From: Bluebead Architects (Office) <studio@bluebeadarchitects.co.uk>
Sent: 13 December 2025 09:01
To: Christos Chrysanthou
Subject: Re: Update on application 11257/APP/2025/2371, 23 Cowley Crescent
Attachments: P090-1-Proposed Site Plan.pdf; P100-Proposed Ground and First Floor.pdf; P302-Proposed Street Elevation.pdf; 251212 - Cycle Store Information - 23 Cowley Crescent - Bluebead Architects.pdf; P090-5-Proposed Site Plan - Parking Layout.pdf; 251212 - Asgard Annexe SBD Guide.pdf; 251212 - Asgard Annexe SBD Technical Information.pdf

Please see attached the additional documents pertaining to the proposed cycle store in response to Highways.

**Sheet No.**  
0040-P090-1

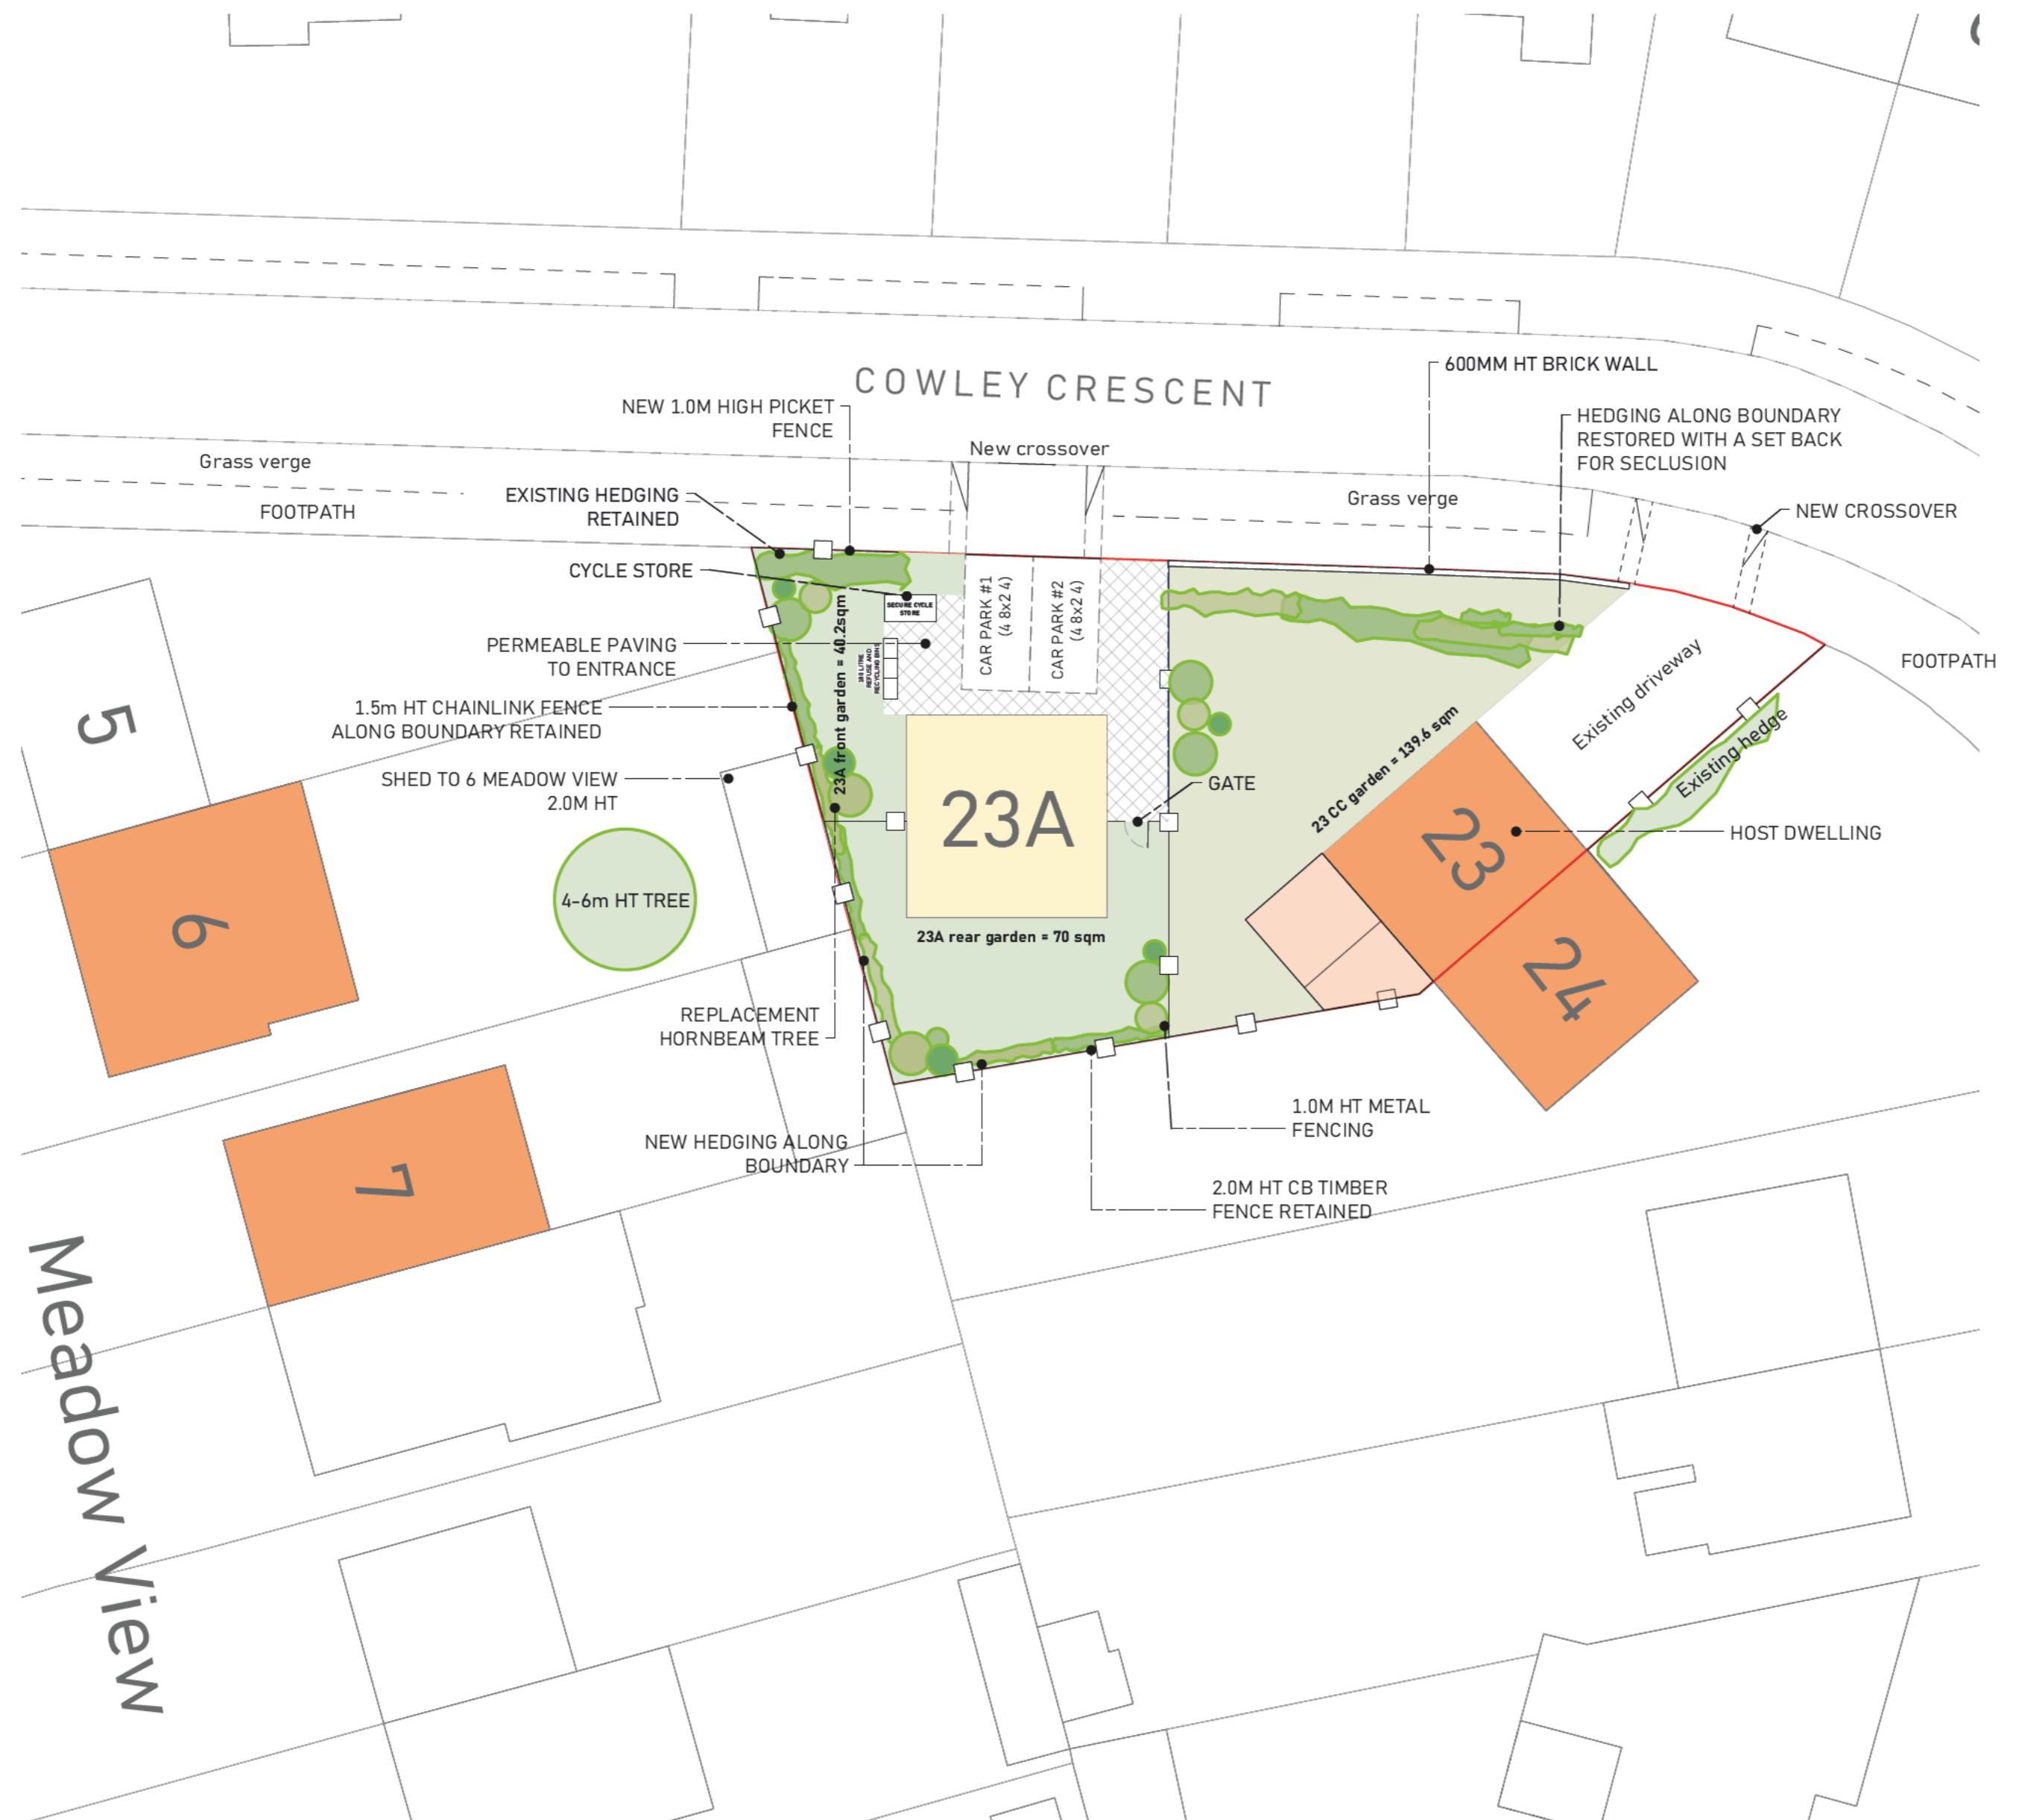
Please note, a few typos have also been fixed regarding the fencing provision — the fencing separating 23A Cowley from 23 Cowley shall be 1.0m high at the front and 2.0m high at the back to separate the gardens. This is reflected in:

- Drawing P090-1 (Proposed Site Plan),
- Drawing P302 (Proposed Street Elevation).
